**From:** Loveday, Mike, Vodafone Group <mike.loveday@vodafone.com>  
**Sent:** Thursday, 9 May 2013 3:07 PM  
**To:** Public Hazzard's Office Email  
**Subject:** [Correction and Apology]: MP 09\_0066 MOD 6 - Chatswood Albert Ave/Thomas St Development Concerns

**From:** Loveday, Mike, Vodafone Group  
**Sent:** Thursday, 2 May 2013 5:12 PM  
**To:** The Hon. Brad Hazzard (MLA), Minister for Planning and Infrastructure  
**Subject:** MP 09\_0066 MOD 6 - Chatswood Albert Ave/Thomas St Development Concerns

COMPARABLE
HEIGHT STUDY
A-0201
SECTION 75W MODIFICATION 6

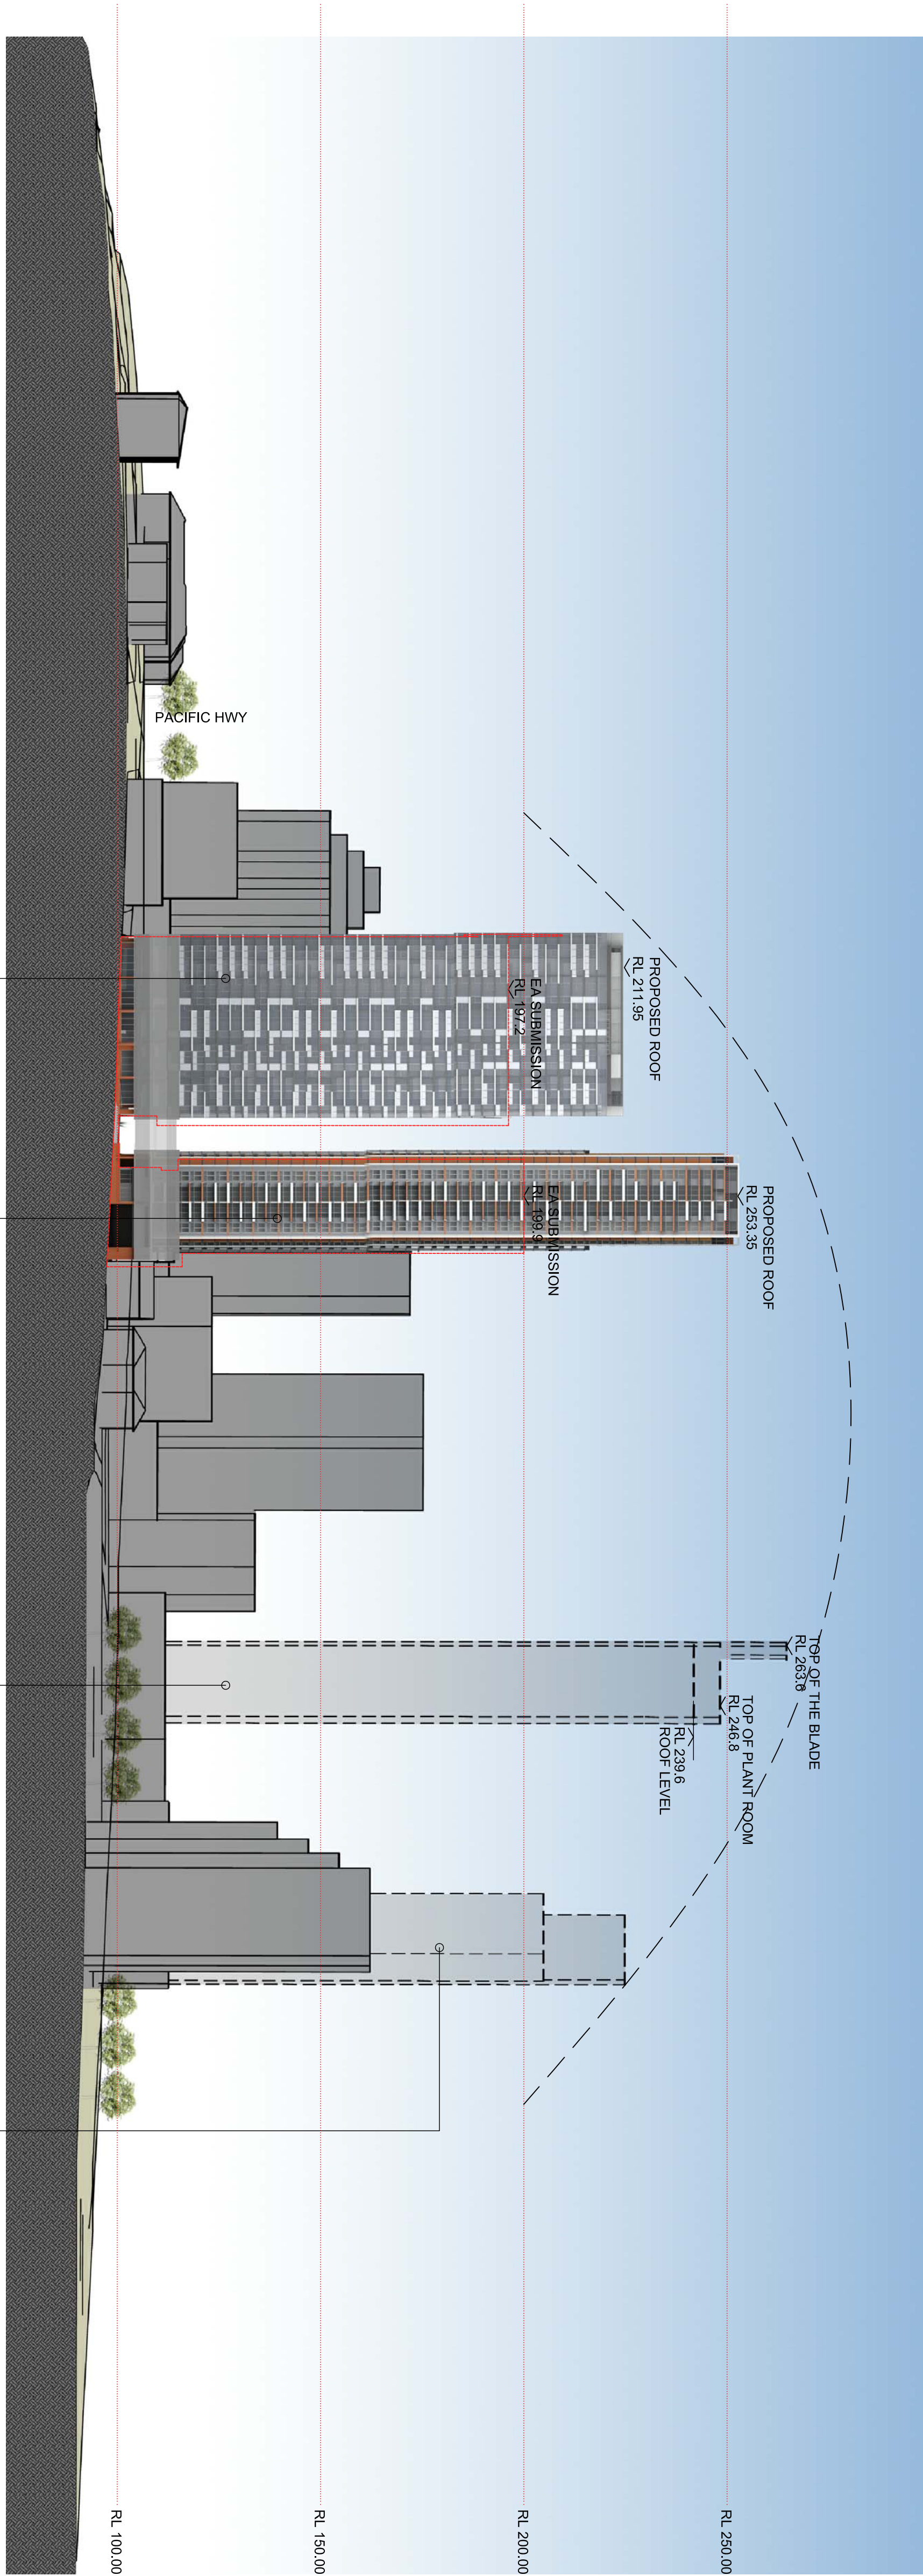
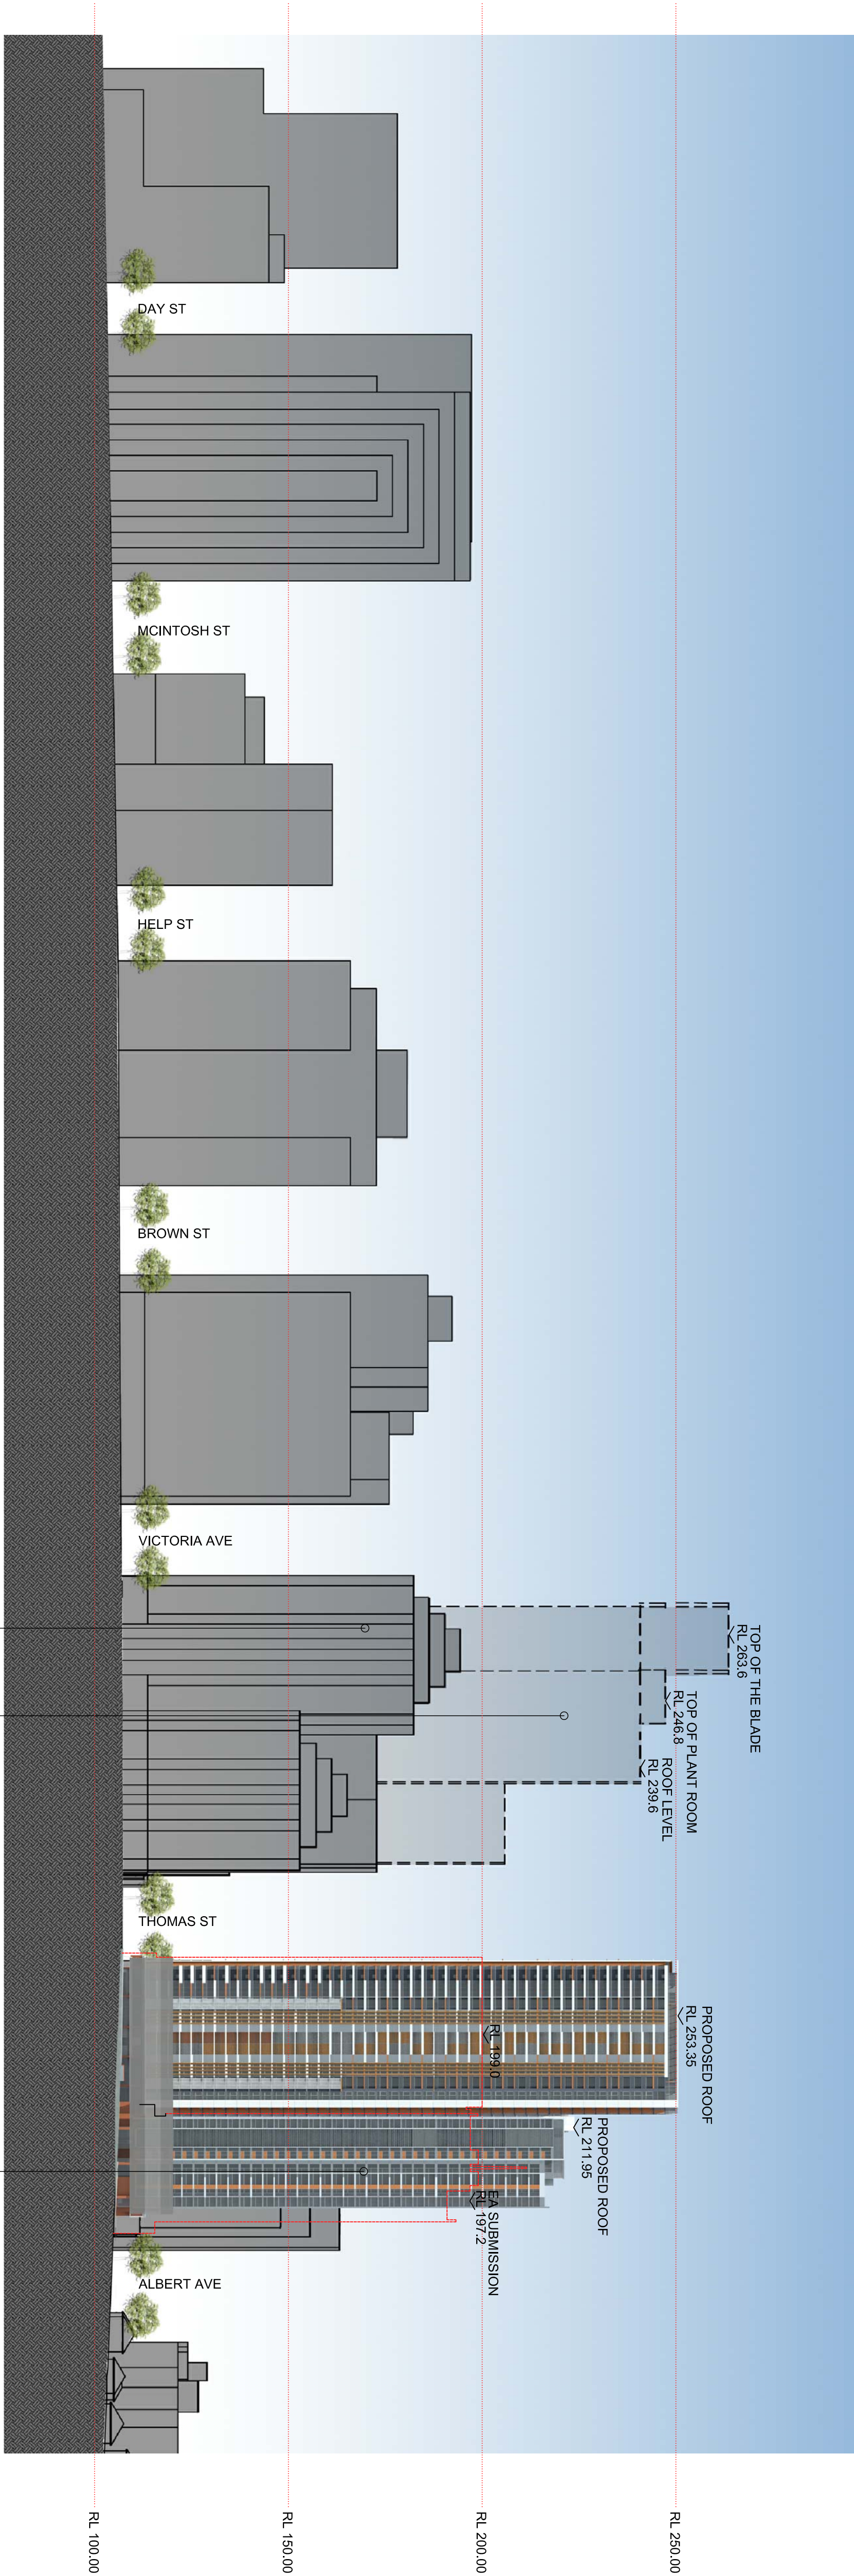
Our note to you on May 2 referred to the proposed Albert Avenue Towers in Chatswood (MOD-6) as being the tallest in Sydney which is not the case. We have discovered that the height references provided to us for the Sydney CBD towers from the Urban Habitat reference is not the same as the standard Relative Level references used in the MOD-6 planning documents. I apologise for this mistake.

Tower-2 with a proposed height of 222M would bring this tower close to the height of Meriton World Square, today the tallest residential building in Sydney located in the centre of Sydney CBD. Tower-1 would become the tallest building in Sydney at 253M, surpassing even Citigroup Tower at 2 Park St in the Sydney CBD holding the current record at 243M (international standard of the Council on Tall Buildings and Urban Habitat). The height of both towers especially Tower-2 (given the bulk form of the rectangular profile) is completely inappropriate 11kms north of the Sydney CBD in a residential fringe area on the edge of Chatswood, bordering residential buildings only 8 and 3-4 stories high.
